## WEST SUSSEX COUNTY COUNCIL CONSULTATION

| <b>FROM:</b>                    | WSCC - Highways Authority                                                                                                                                       |
| <b>LOCATION:</b>                | 4 Beechlands Cottages & Land adjacent, Beechlands Close, East Preston, BN16 1JT                                                                                 |
| <b>SUBJECT:</b>                 | EP/168/19/PL<br><br>1 no. dwelling & alterations to roof of existing dwelling (4 Beechlands Cottages) including the provision of new dormer to front elevation. |

Cycle Store

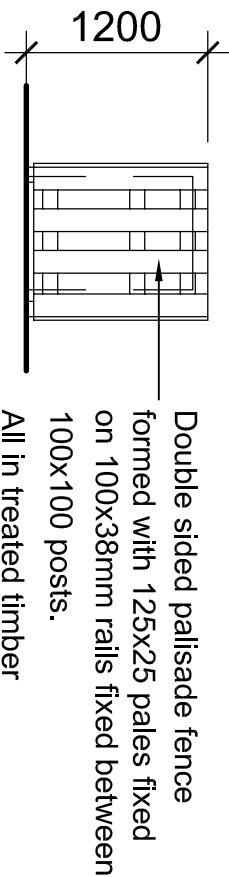
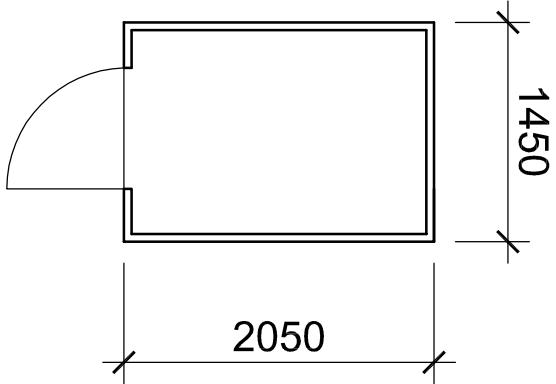
In terms of cycle parking, the applicant proposes a shed to the rear of the plot, which will be utilised for cycle storage. Under WSCC parking standards, residential dwellings with three or more bedrooms should provide secure and covered cycle parking for at least two cycles. The inclusion of cycle parking helps promote the use of sustainable alternative modes of transport to the private car.

No part of the development shall be first occupied until covered and secure cycle parking spaces have been provided in accordance with plans and details submitted to and approved by the Local Planning Authority.

Site Plan

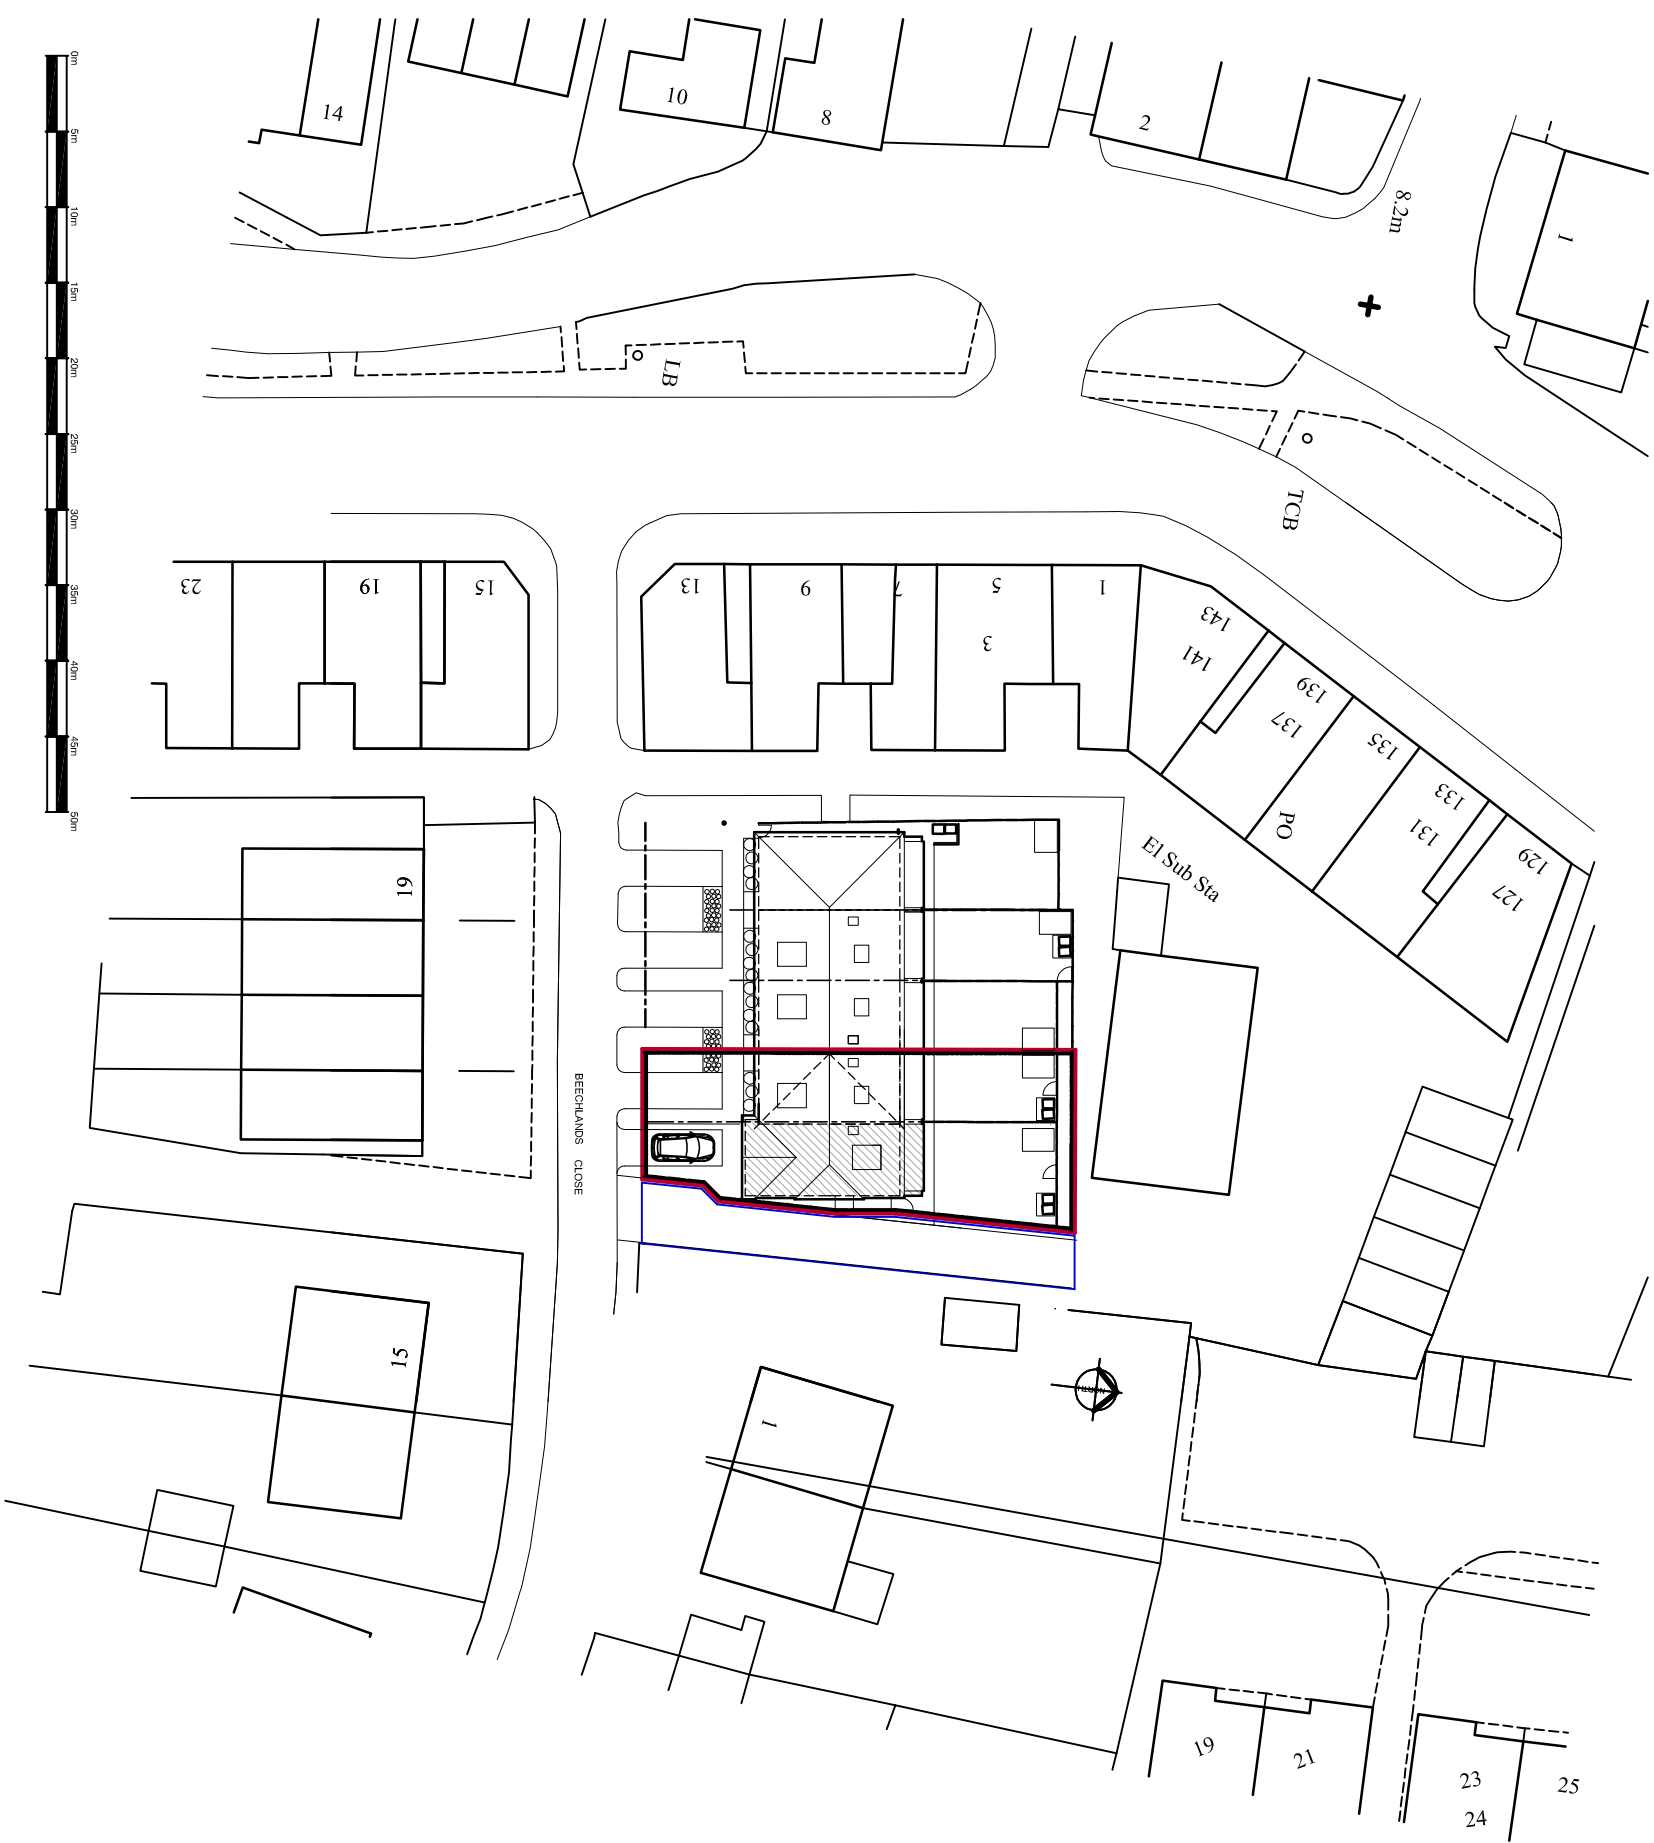
The proposed parking space will utilise the existing dropped kerb fronting the property. There are no apparent visibility issues at this access. An inspection of collision data provided to WSCC by Sussex Police from a period of the last five years reveals no recorded injury accidents within the vicinity of the site. Therefore, there is no evidence to suggest the existing arrangement is operating unsafely or that the proposal would exacerbate an existing safety concern.

The side access that currently serves garages to the rear will be reduced in width to approximately 3m at its narrowest point. The LHA notes that two vehicles will not be able to pass one another whilst using this access. However, given that the garages are anticipated to generate a low level of traffic, the likelihood of conflict between two vehicles would be negligible. Furthermore, there is sufficient width for vehicles to pull in from the highway at the entrance and wait for an oncoming vehicle to exit.

The applicant proposes one off-street car parking space for the new dwelling. The parking bay meets the minimum specifications for single car bays as set out in Manual for Streets (MfS). The WSCC Car Parking Demand Calculator has indicated that a dwelling of this size in this location would create a demand for three car parking spaces. Therefore, overspill parking would have to be accommodated on-street.

On-site turning does not appear achievable, so vehicles may have to exit the site in a reverse gear. However, Beechlands Close has good forward visibility and neighbouring properties operate similar arrangements with no known highway safety concerns.

No part of the development shall be first occupied until the car parking has been constructed in accordance with the approved site plan. These spaces shall thereafter be retained at all times for their designated purpose.
